**KIRKLEES METROPOLITAN COUNCIL  
INVESTMENT & REGENERATION SERVICE**

| Reference No:         | <b>2023/62/93348/W</b>                                                                             |
| Site Address:         | 22, Goldcrest Court, Netherton, Huddersfield, HD4 7LN                                              |
| Description:          | Erection of single and two storey extension to dwelling and single storey extension to outbuilding |

Proposed Plans and
Elevations

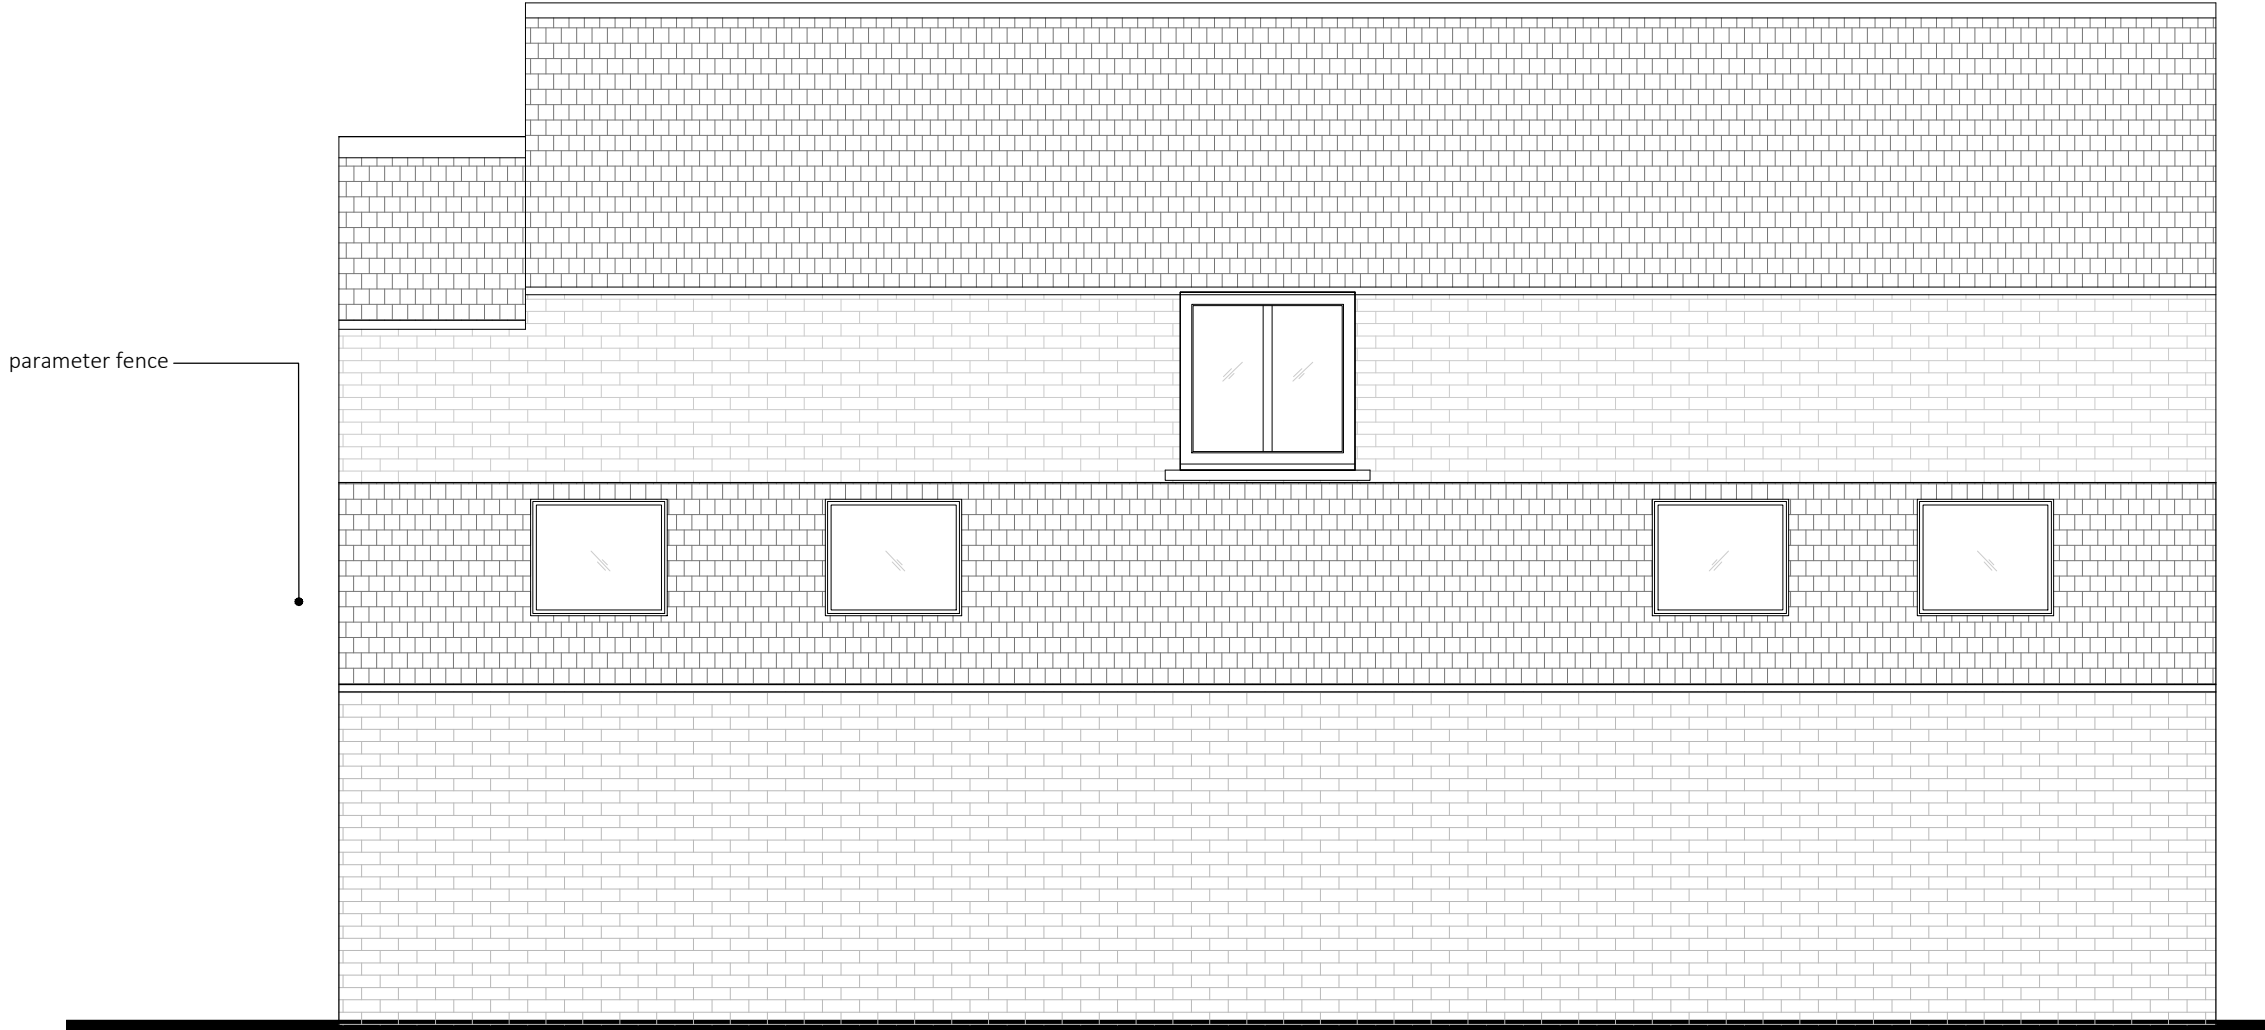
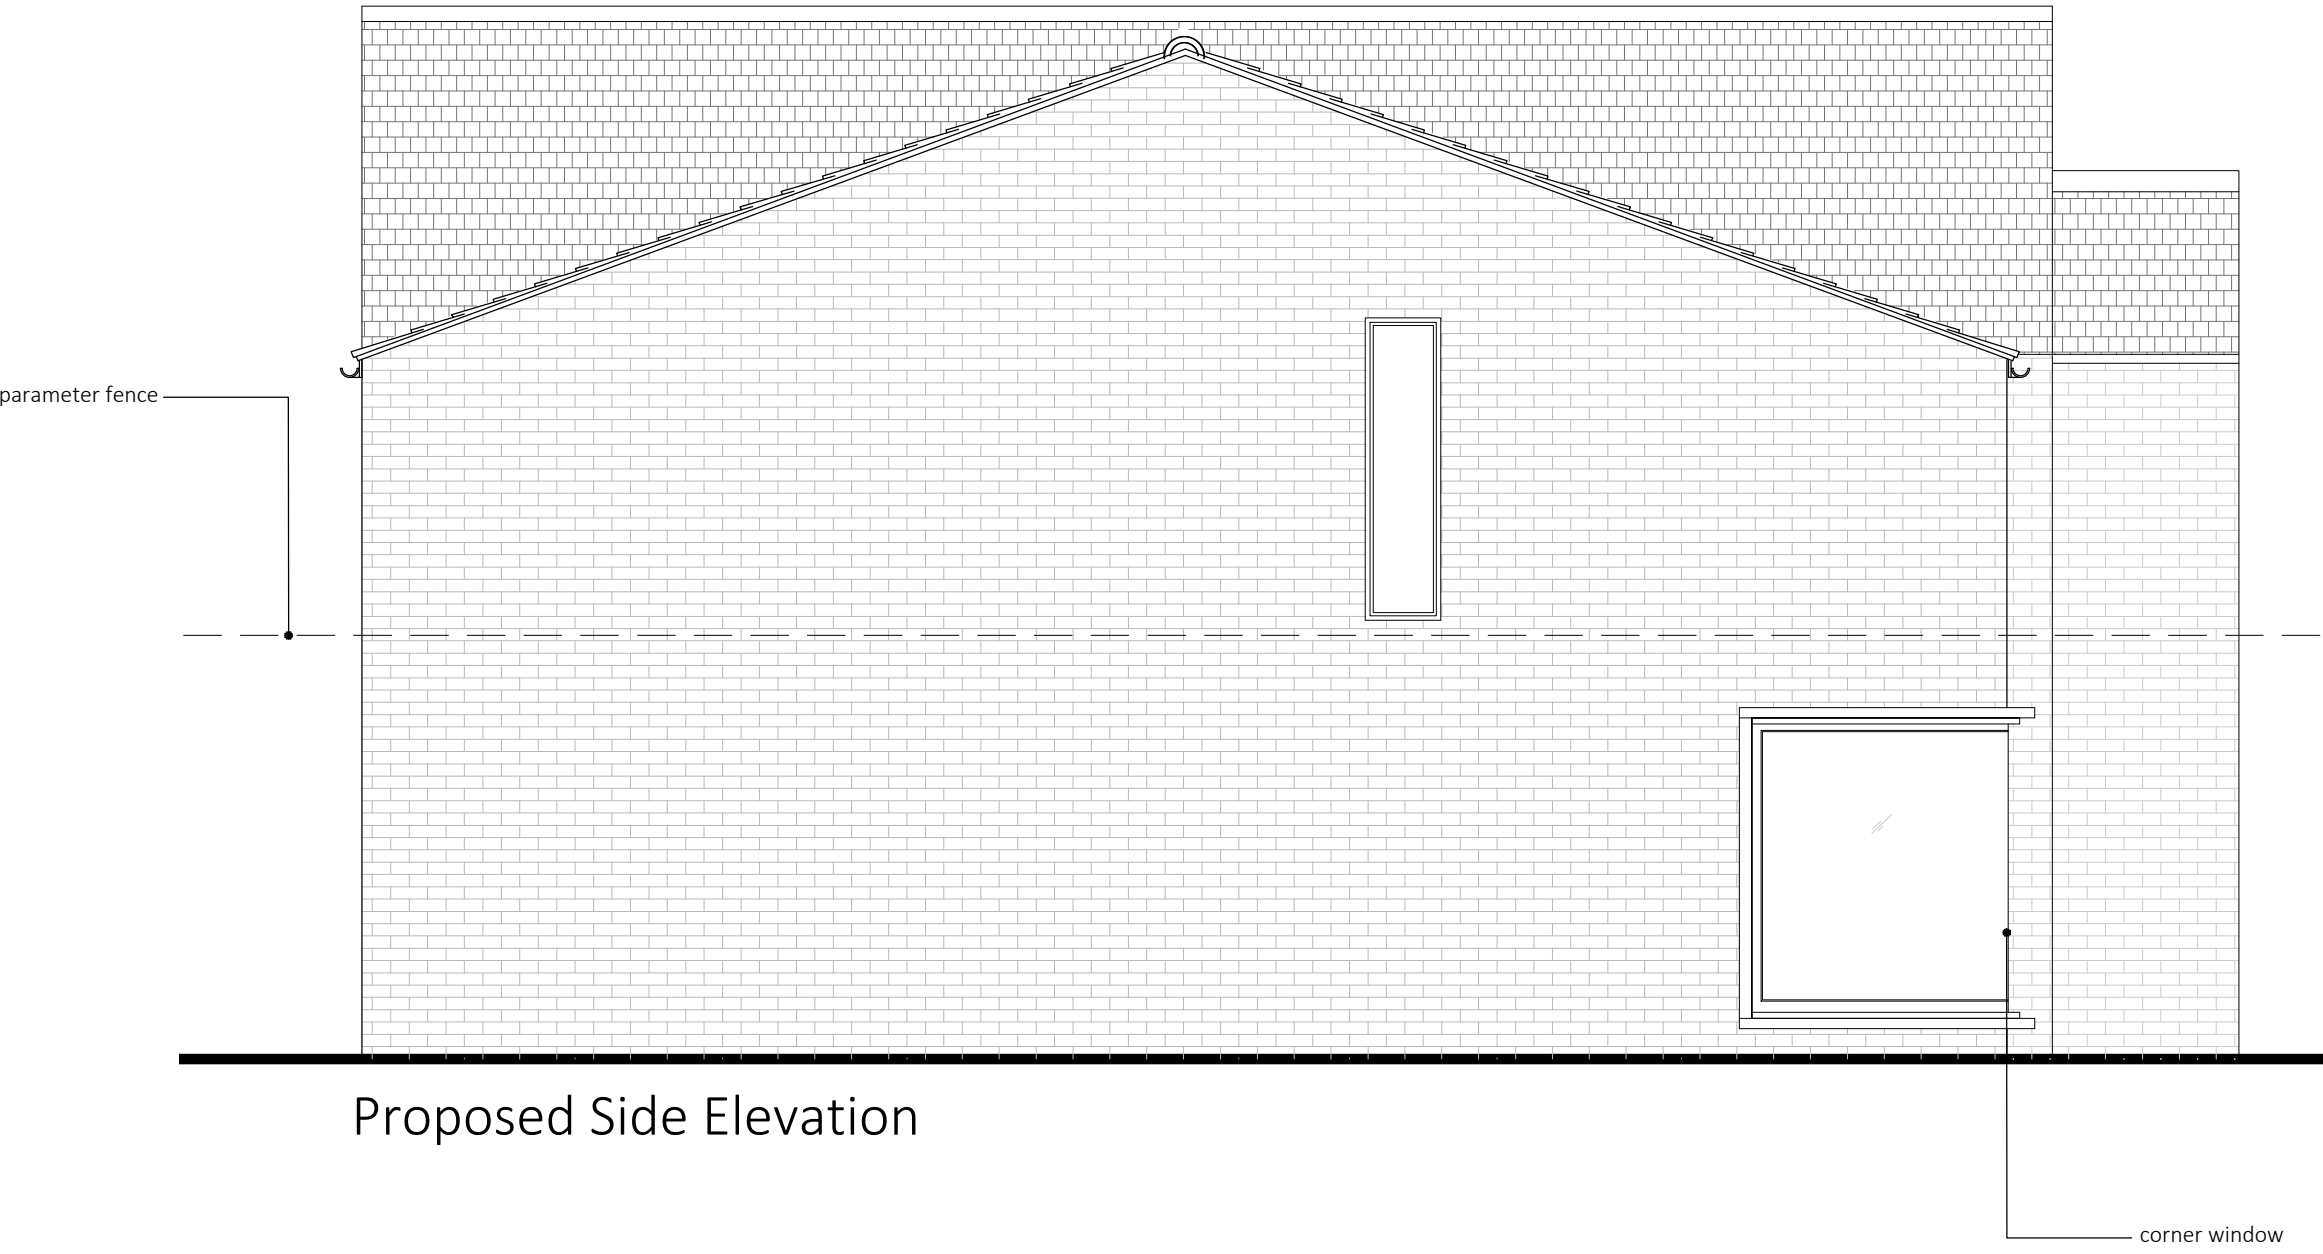
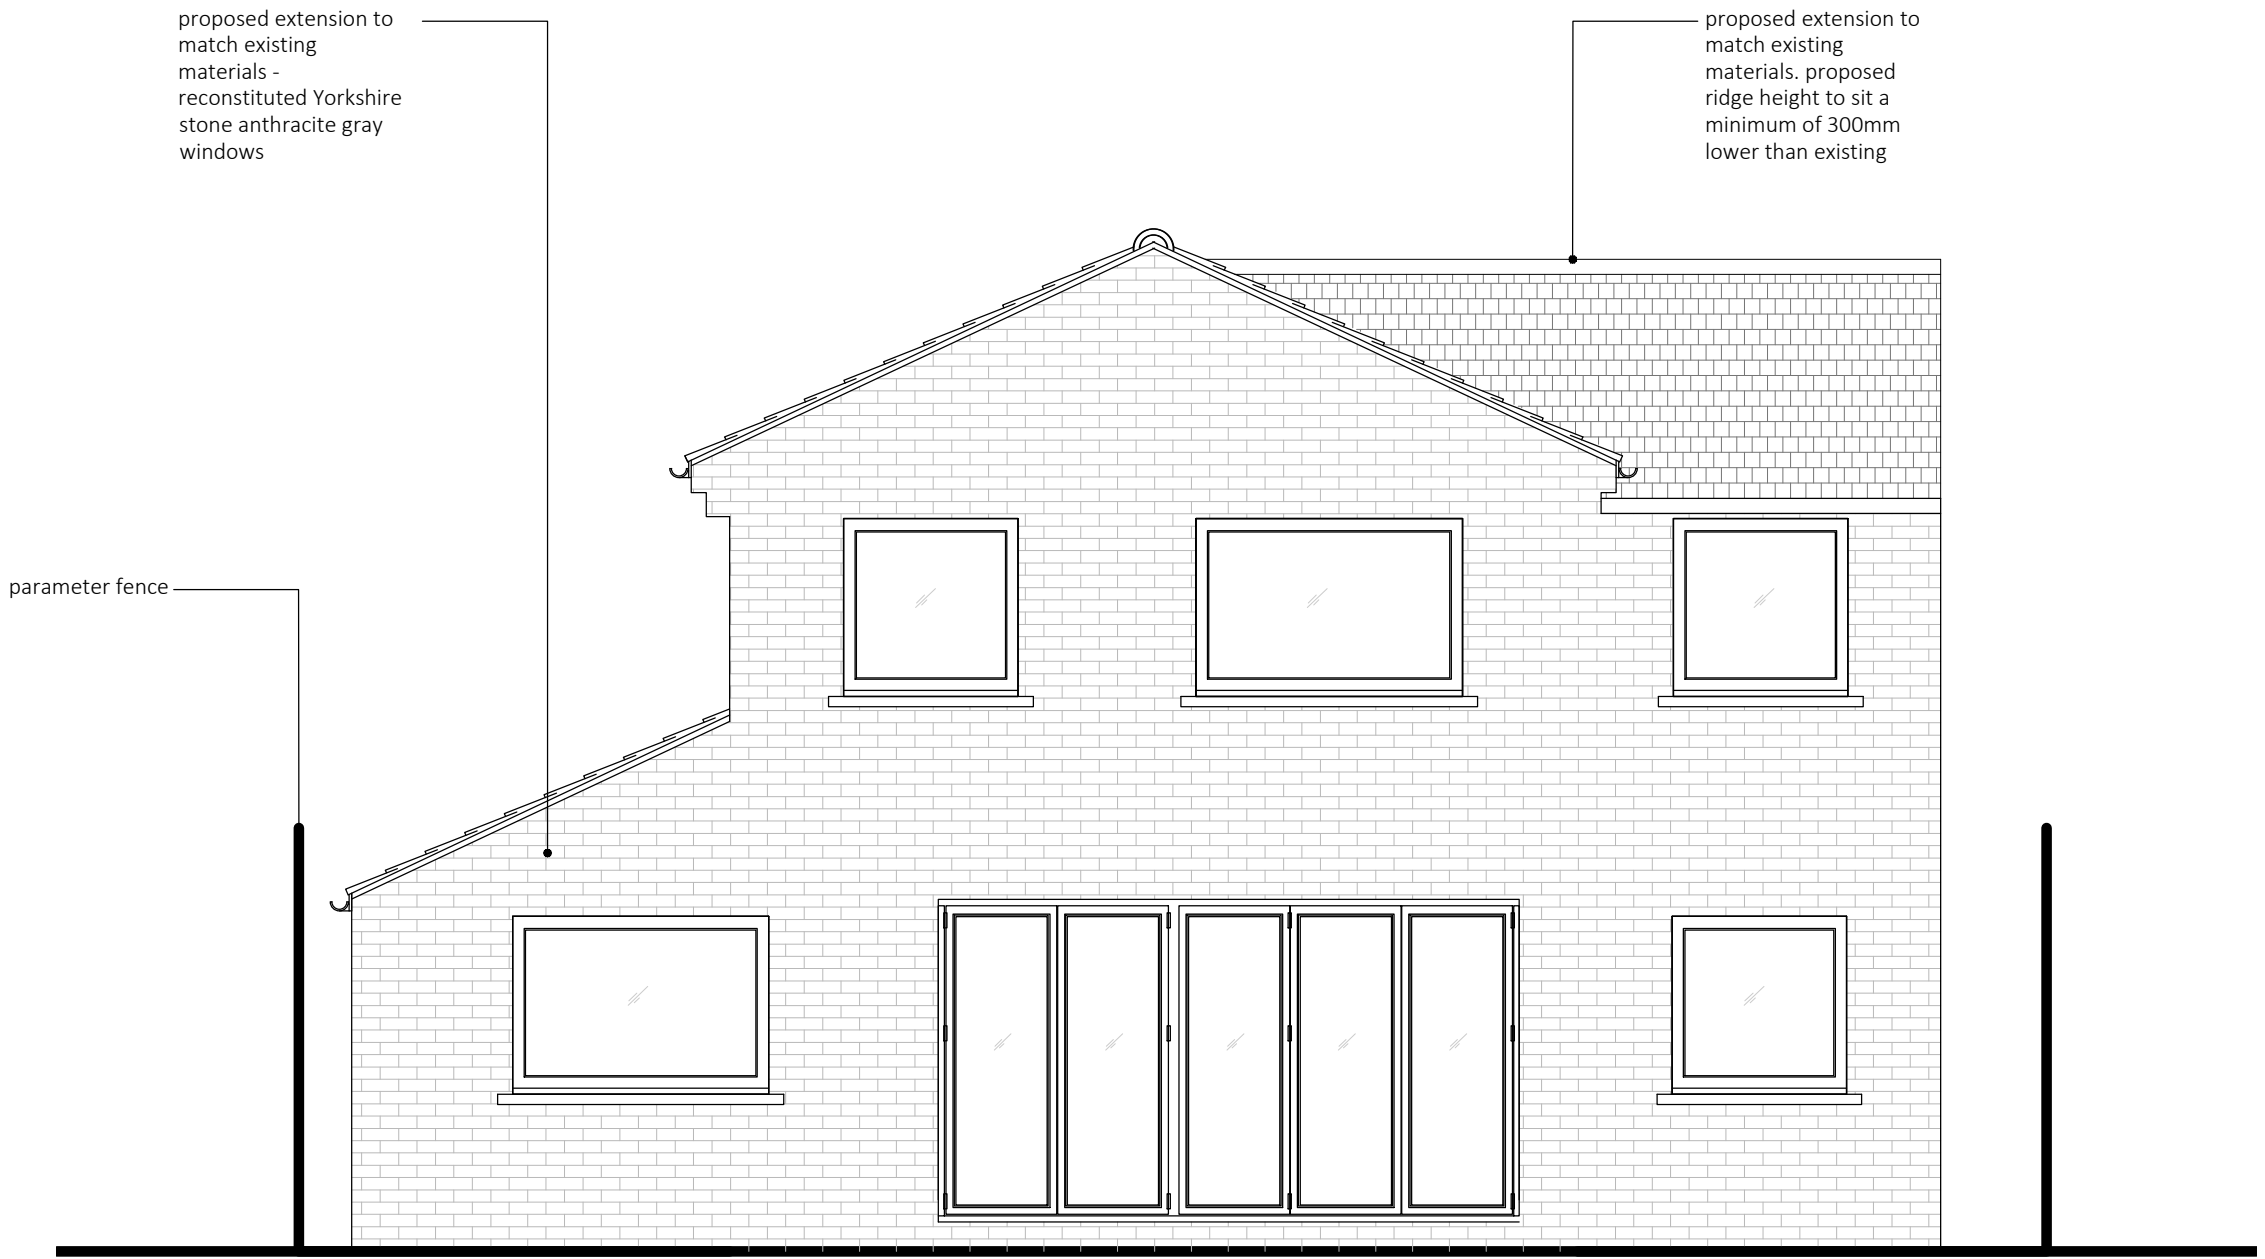
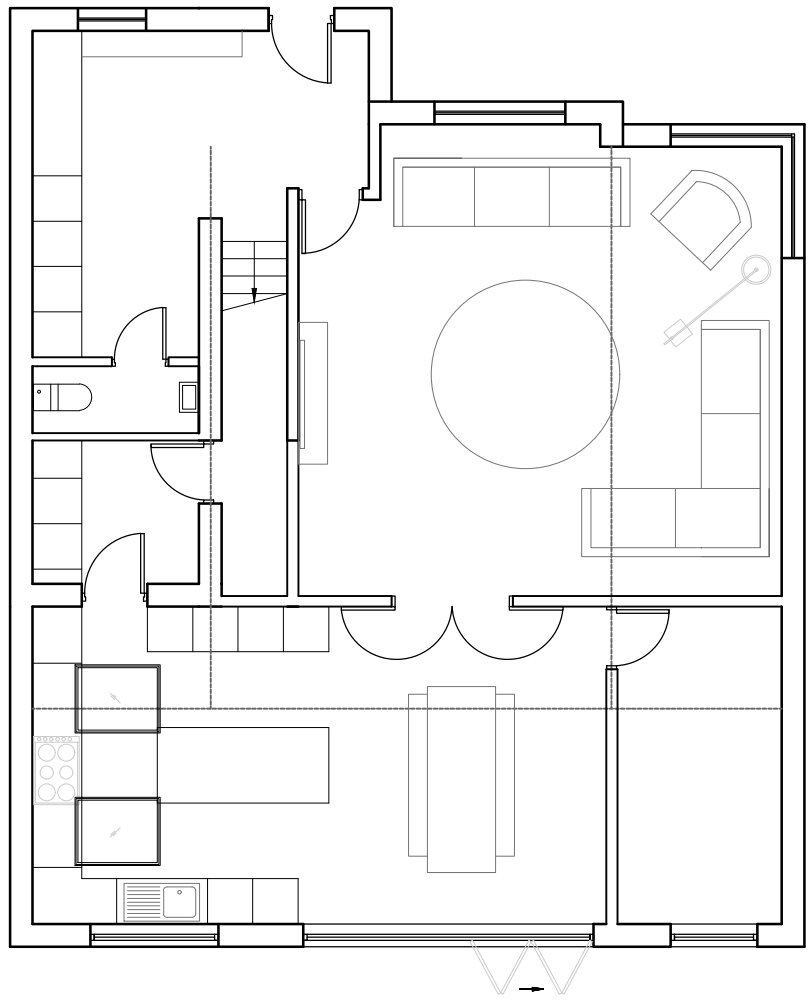
Firstly, the proposed front extension is two-storey in height and is not considered to be of a small or subservient design to the original building. It would project forward of the principal elevation of the host dwelling by 1.2 metres and is not considered to be sufficiently set down, with the ridge height of the front extension to meet the eaves height of the host roof.

The design of the proposed single storey side extension is contrary to the recommendations as set out within the House Extensions and Alterations SPD. Whilst the width of the proposed single storey side extension would not exceed two thirds of the width of the original house or the height exceed 4 metres, the extension would project forward of the principal elevation of the host dwelling by 1.2 metres.

The design of the proposed two-storey side extension to 22 Goldcrest Court is contrary to the design principles of the House Extensions and Alterations SPD as set out above. The two-storey side extension would not appear as a subservient addition to the host property, presenting an undue extent of additional bulk/massing to the front and side of the dwellinghouse.

The projection of the side extension would abut the shared boundary with No. 24 Goldcrest Court to the rear and the majority of the built form that makes up the side extension would be separated from this shared boundary by less than one metre. In addition, the ridge height of the extension would be set down from the ridge height of the host dwelling by only 0.2 metres and would be set back only 0.3 metres from the principal elevation of the host property.

The proposed two-storey side extension would introduce a solid blank elevation which abuts the shared boundary with No. 24 to the rear and the majority of the built form that makes up this side extension would be separated from this shared boundary by less than one metre. As a result of this, it is considered that the proposed two-storey side extension introduces an undue extent of overbearing upon the occupiers of this neighbouring property and would be unduly oppressive.
